5 August 2020

**Re: Epiq Estate Lennox Head (Pacific Pines Estate) – Response to Submissions and Additional Information (MP 07\_0026 MOD 7)**

Matthew Wood  
**Director**  
**Planning and Environmental Health Division**

**EPIQ LENNOX HEAD ILLUSTRATION**  
**C7 - STORMWATER CONCEPT**  
**PLAN** Rev A  
CLIENT: CLARENCE PROPERTY CORPORATION  
LOCATION: LOT 234 DP1104071  
LENNOX HEAD NSW  
DATE: 20.08.18 REF: 14/351  
SCALE: 1 : 4000 @ A3 DRAWN: bk

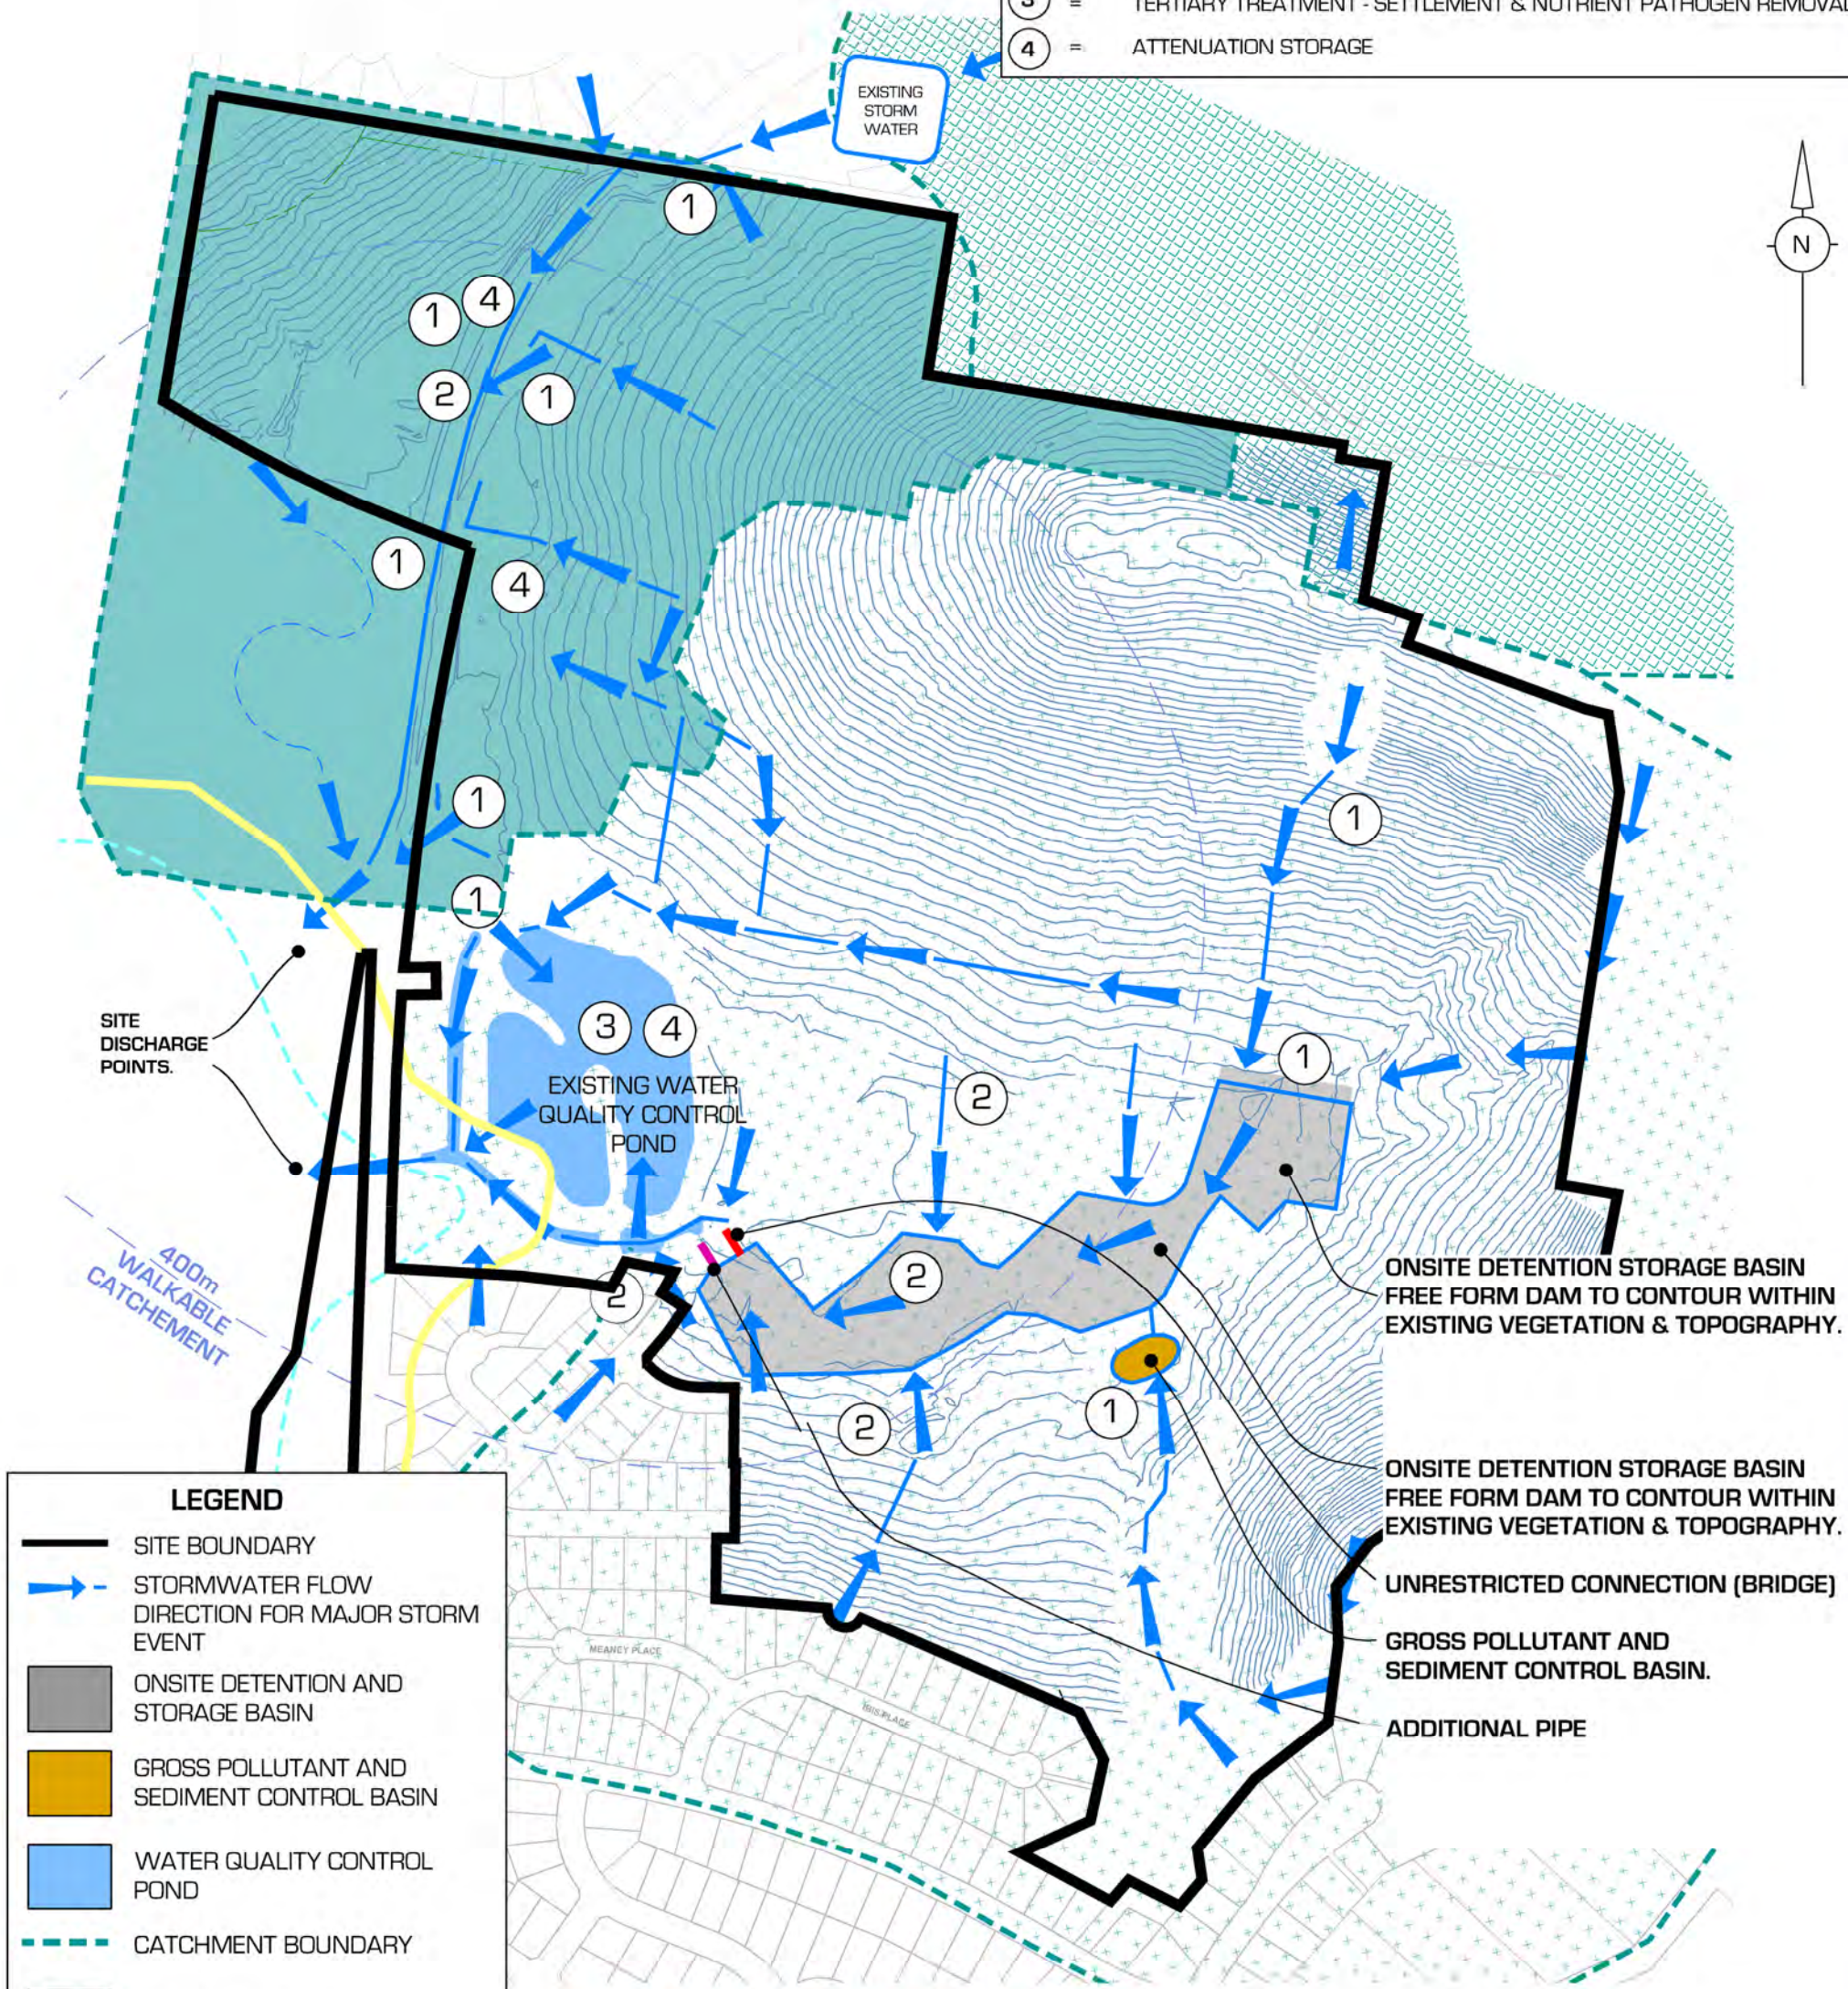
- Due to the proposed land forming, the majority of stormwater from the development is to be discharged directly into the Conservation Management Zone above Montwood Drive. Thus, discharged stormwater will be required to move through a large portion of the Conservation Zone before it enters the water treatment pond.

Council is of the view that if the land forming was directed towards Montwood Drive the majority of stormwater from the development could be discharged to the western side of Montwood Drive. The benefit of discharging stormwater into this location it a more direct and shorter route to the water treatment pond. In addition, the developer has already constructed a drainage pathway and maintenance track in this area (Plates 1 and 2).

Site Layout Plan - Level I
5551.13.04.D

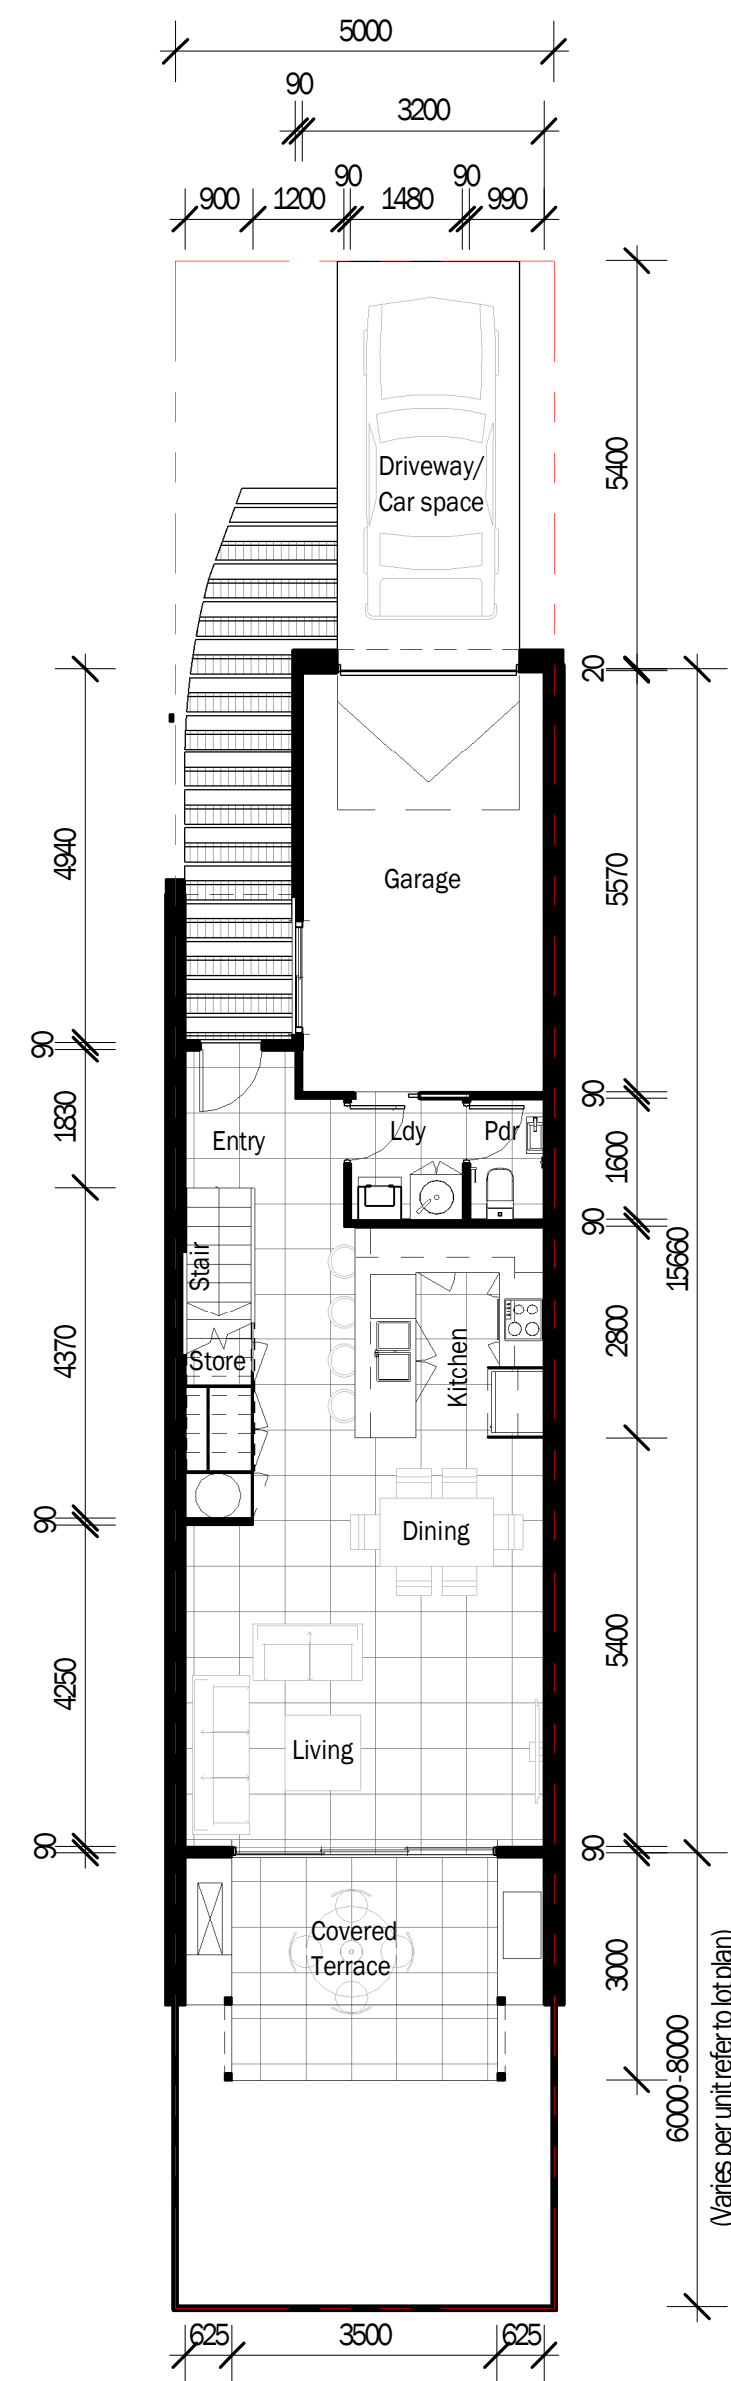
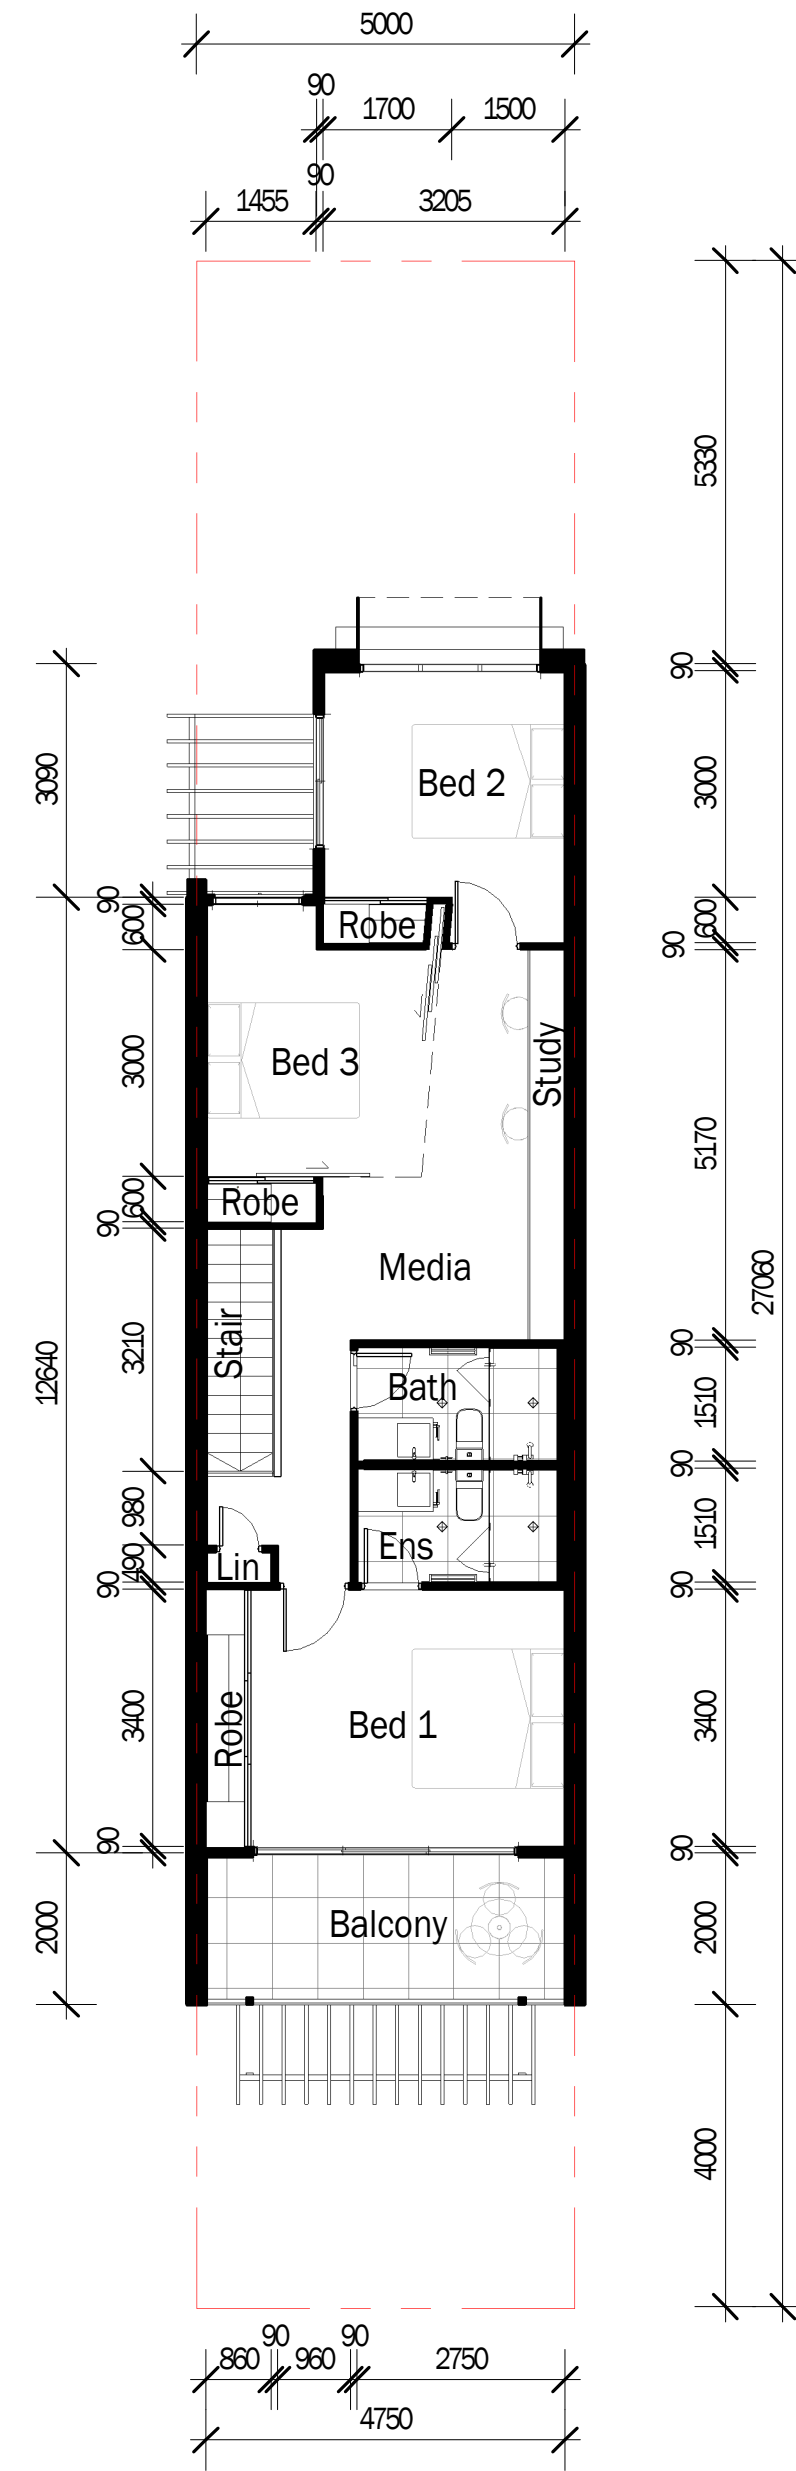
- Council's minimum DCP standard for dwellings on Torrens title lots is two car parking spaces and stacked parking is acceptable. Type A dwelling designs provide a single car garage and provision for another stacked car parking space on the driveways. However, the driveway/stacked car parking space is not contained wholly on the allotment, but continues across onto the road reserve verge. The proposal should be amended to ensure that the second mandatory car parking space is fully contained within each proposed Torrens title allotment.
- The subdivision provides for 133 allotments, with 55 on street parking spaces. Council's view is that this is not an abundance of on street parking. This reinforces the importance of achieving provision of at least two car spaces wholly within each allotment.

- The sizes of smaller allotments may require adjustment to ensure two cars can be parked wholly within each allotment (e.g. proposed Type A buildings).

- A minimum of two residential car parking spaces being provided to each dwelling, in accordance with the Ballina DCP 2012, contained wholly within the subject allotments (this is not presently achieved for Type A units).
